**Consultation Response from KC,
Highways Development Management**

2024/93077 Dunkirk Inn, 231, Barnsley Road, Lower Denby, Huddersfield, HD8 8TX

Discharge details reserved by conditions 15 (waste/recycling facilities), 16 (charging electric vehicles), 17 (landscaping), 18 (residential amenity) on previous permission 2020/91601 for change of use from agricultural land to Sui generis Drinking Establishment (previously A4) and erection of extensions and alterations

Date Responded: 12/12/2024

Drawing DC01  
Electrical Vehicle Charging and Recycling Facilities  
at  
The Dunkirk Inn, 231 Barnsley Road, HD8 8TX

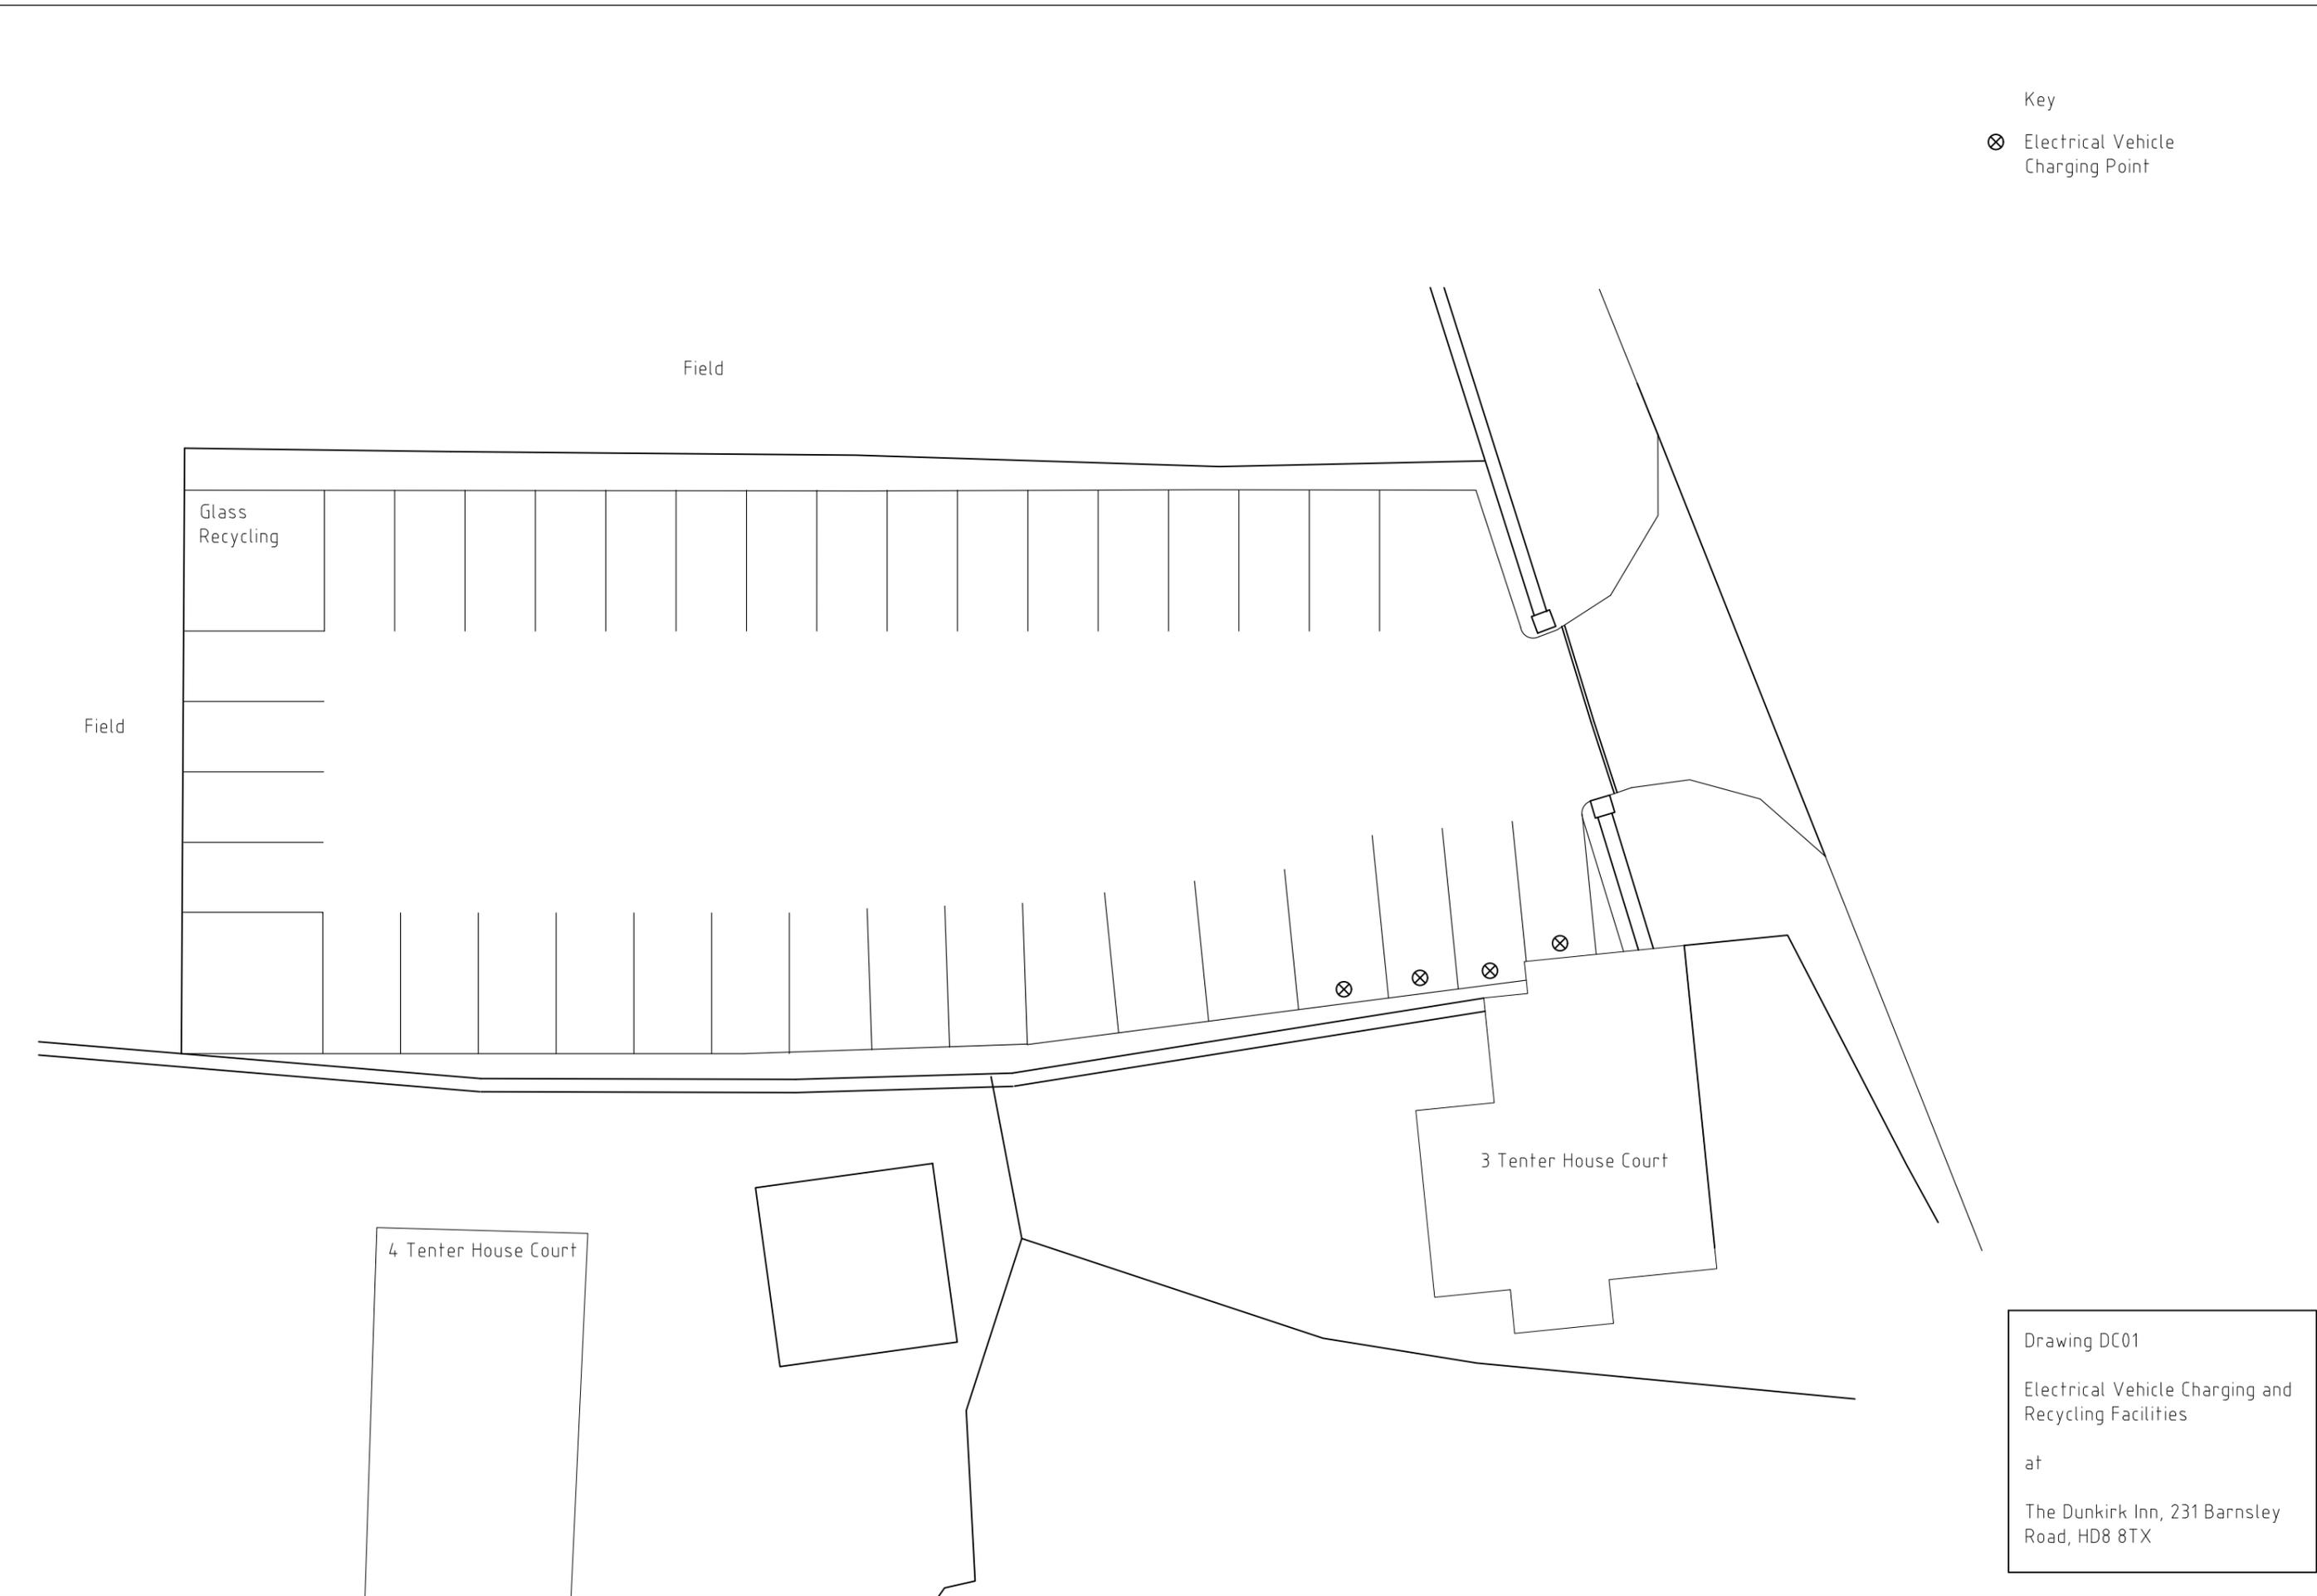
The covering letter information provided with this DoC application explains the process of waste and recycling storage and collection, drawing No PR01 Rev J from the original approval shows the location of waste bins adjacent to the pub, and drawing No DC01 from the current DoC application shows the location of the pub/public glass recycling facilities within the car park.

With this we are satisfied that the information provided is suitable for the discharge of condition 15 of previous permission 2020/91610 on highways grounds.
